Description: To provide production facilities for the manufacture of pizzas, together with associated amenities and facilities

Location: Sluice Road
Holbeach St Marks

Amendment: Reduce size and amend design of reception area at western end of pizza building

**TOWN AND COUNTRY PLANNING ACT 1990
NOTICE OF ACCEPTANCE OF AMENDMENT**

NOTE:
ALL LEVELS RELATIVE TO
SURVEY DATUM OF 100.000m

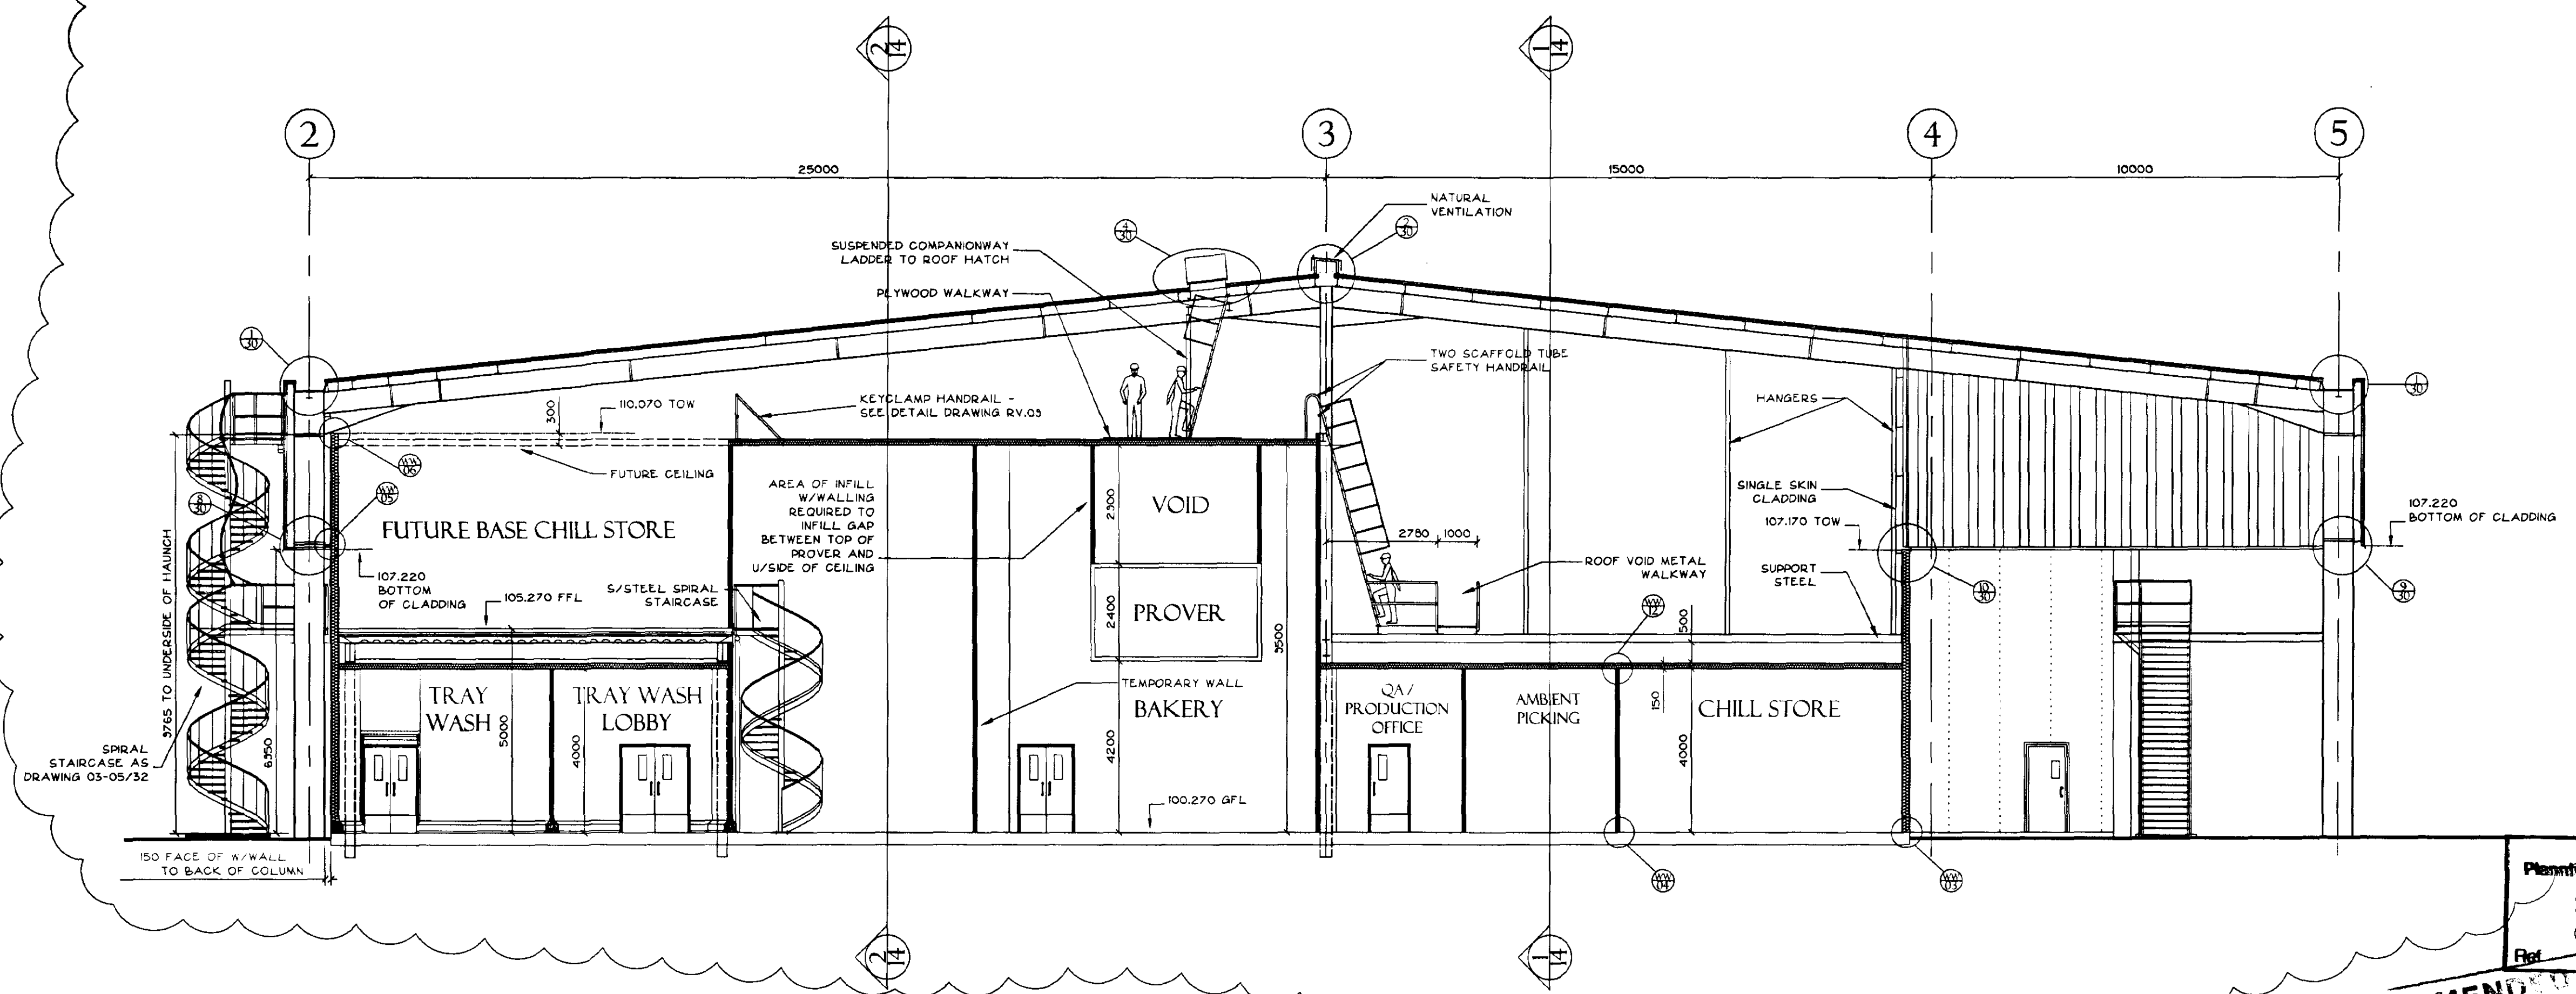
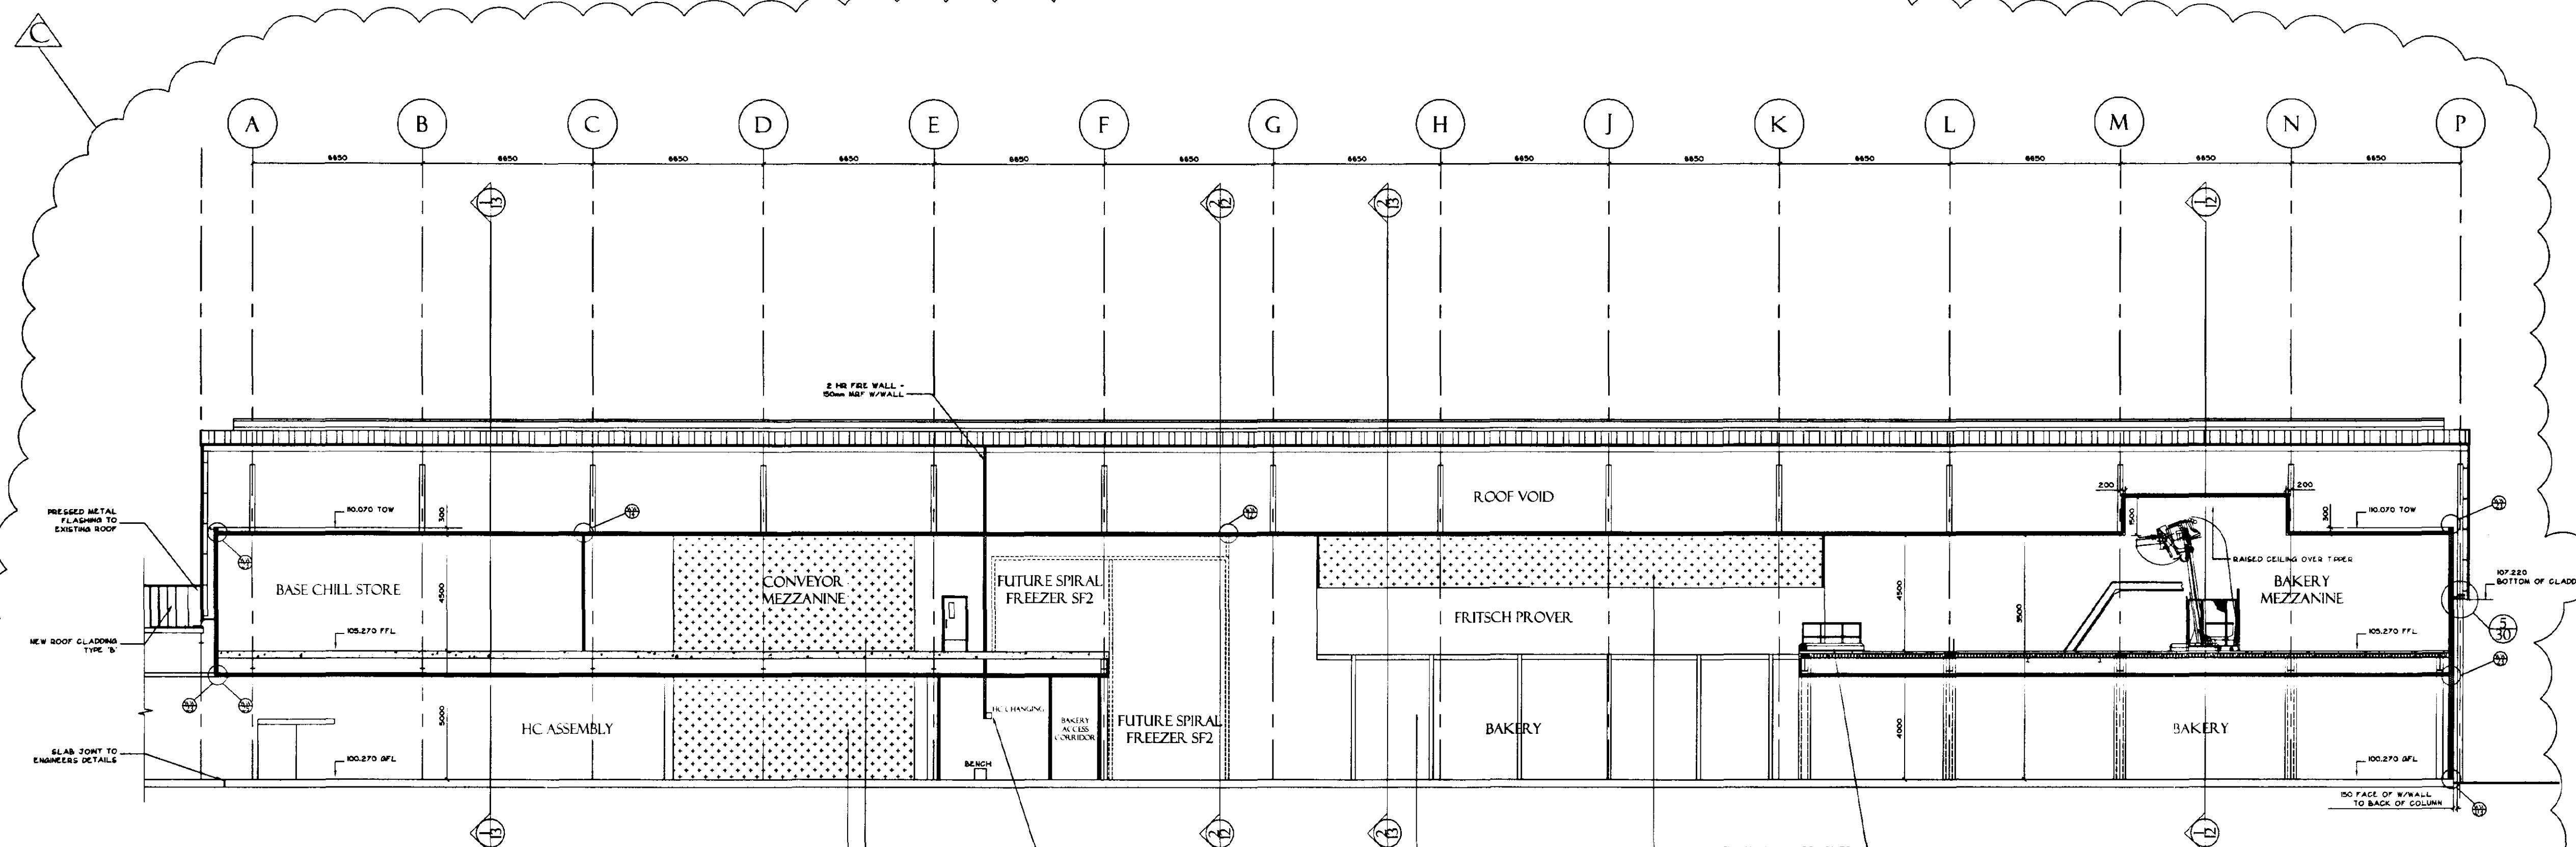
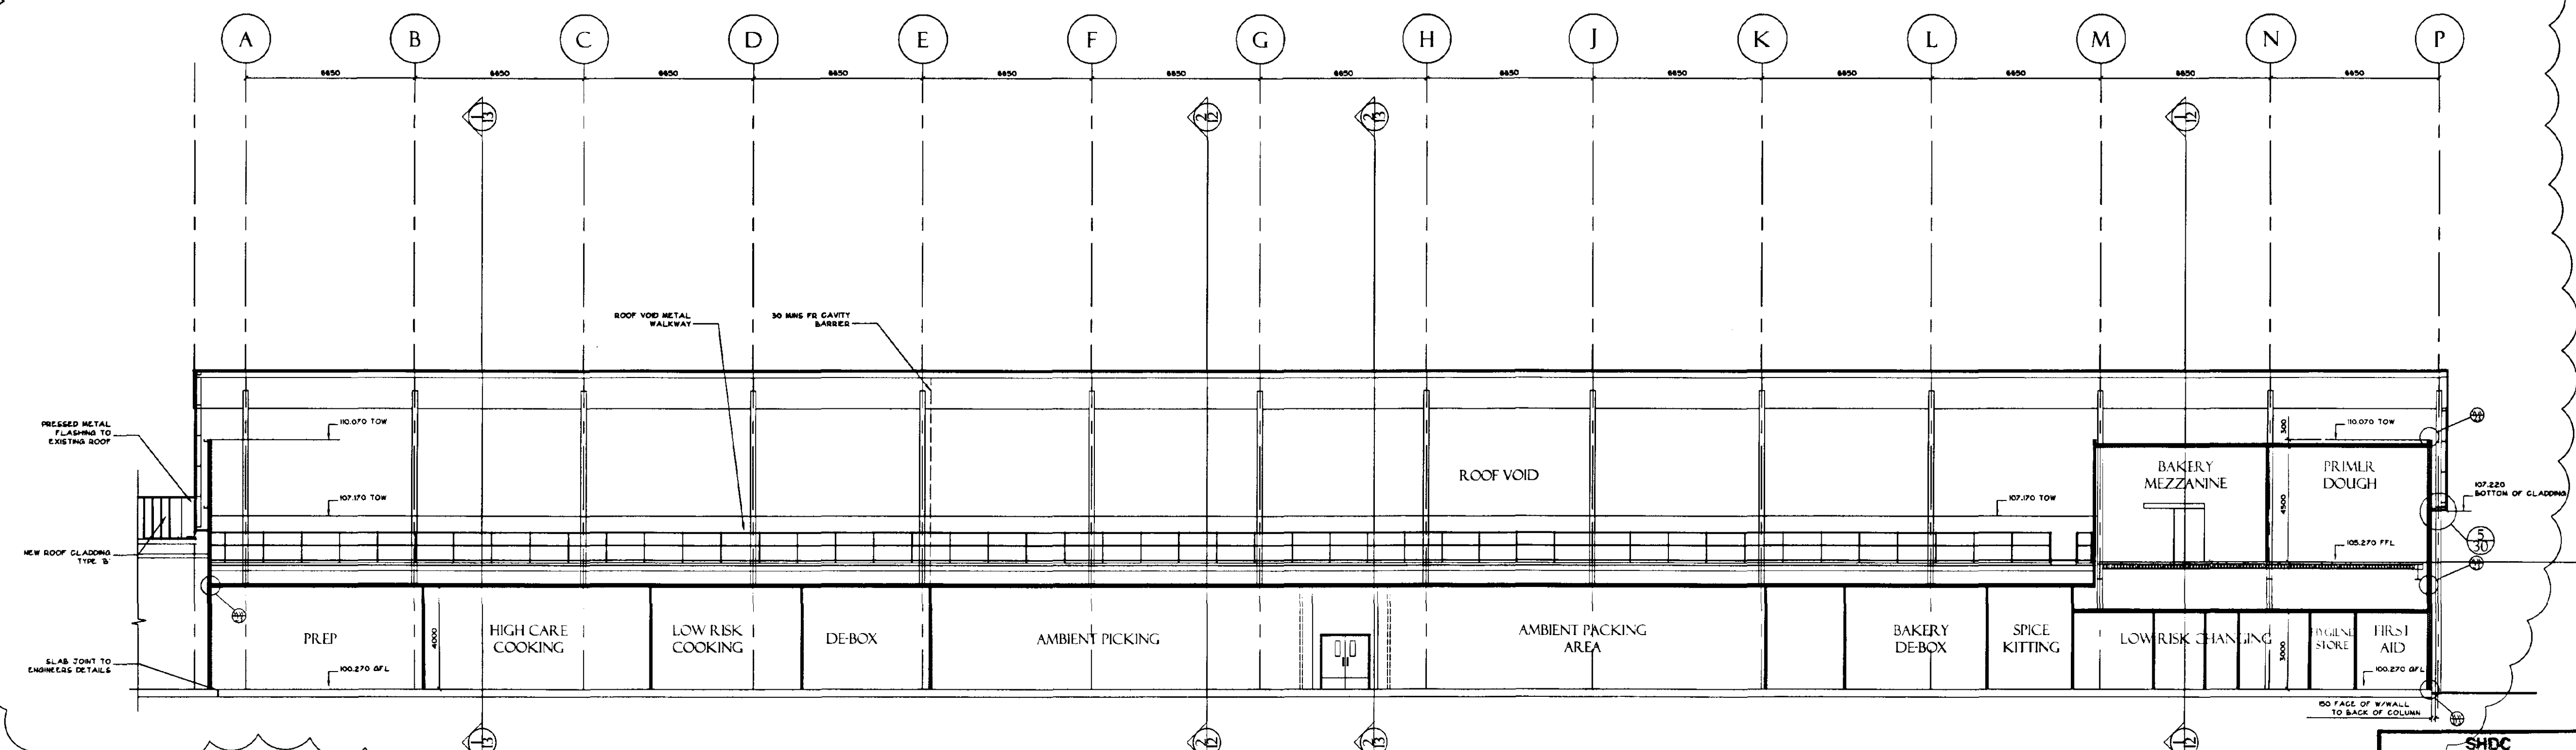
Amendment: Amended building design/layout including reduced height
Dwgs.03-05/02J;/03H;/04C;/05B;/10B;/12F;/13D & /14C

The major change from the original application drawings is the reduction in the main building height of about a metre.

The amended details submitted in respect of the above proposal have now been considered and there are no objections to the amendment being implemented to the extent described above.
